Application number: 2024/93464	
What is the application for?:	Variation condition 2 (plans) on previous permission 2023/91483 for demolition o
Address of the site or building:	adj, 33a, Church Lane, Clayton West, Huddersfield, HD8 9LY
Postcode:	HD7 6NF

Drawing No CVD 01 - Proposed elevations and site plan.
 Proposed dwelling.
 Land adjacent 33a Church Lane, Clayton West HD8 9LY.
 Jan 2025.

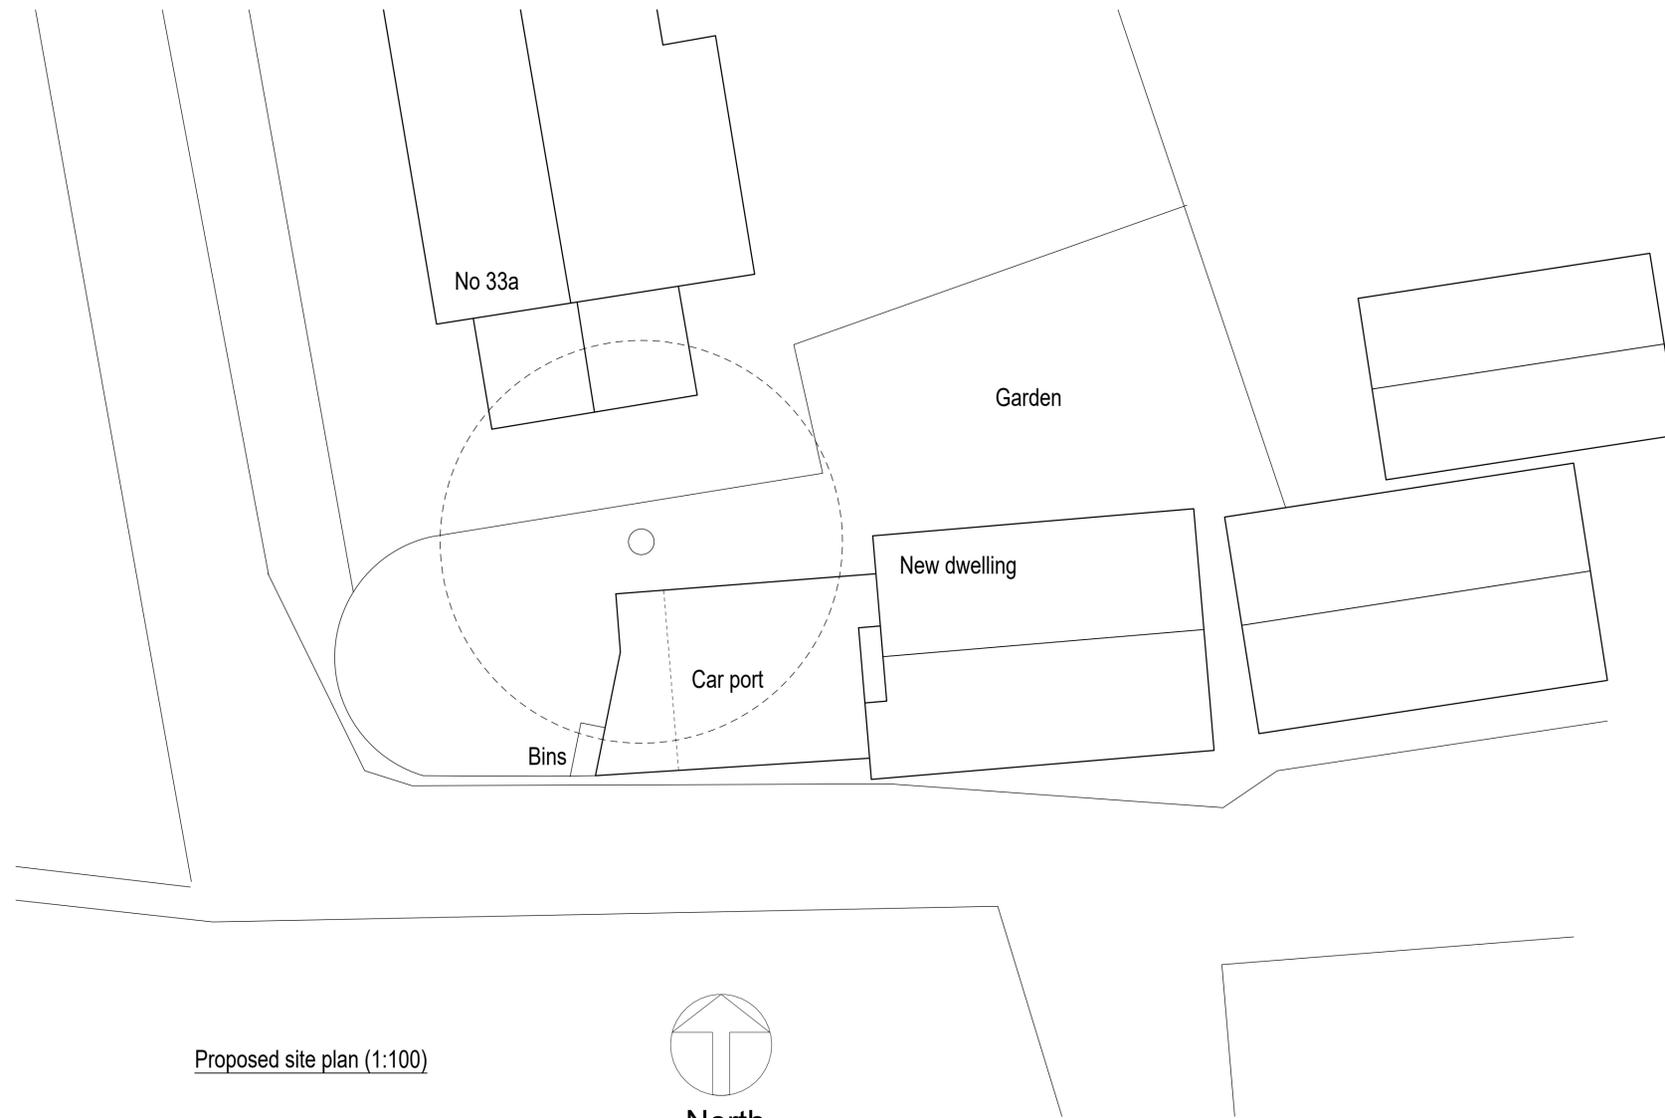
Type of comment: An objection	
Do you wish your comments to be published on the website anonymously?	Yes
<p>I have two principle objections to this proposal.</p> <p>1. The enlargement of the proposed driveway is significant, by approximately 50%. I am seriously concerned about the construction and the damage this will have on the two protected trees in this area, notably this driveway will be within the root protection area. The information provided on this application to support it, namely the tree/arboricultural survey is now outdated. This survey and method statement is based on the previous plans, now that the driveway has been increased by 50% the method statement is no longer applicable to the application. For example the method statement talks about the driveway covering under 20% of the root protection area, now that the surface area of the driveway is being increased this needs to be reviewed.</p> <p>2. They have applied for and been granted permission to lift the crown of the two protected trees to give 5 metres ground clearance. However since being granted permission they have gone on to unlawfully removed branches up to, in my estimation 10 meters. The branches that have been cleared have been significant. I am therefore highly concerned about the unlawful damaged caused to the tree, and additionally that the builders are now unlikely to comply with the restrictions given giving further concern.</p>
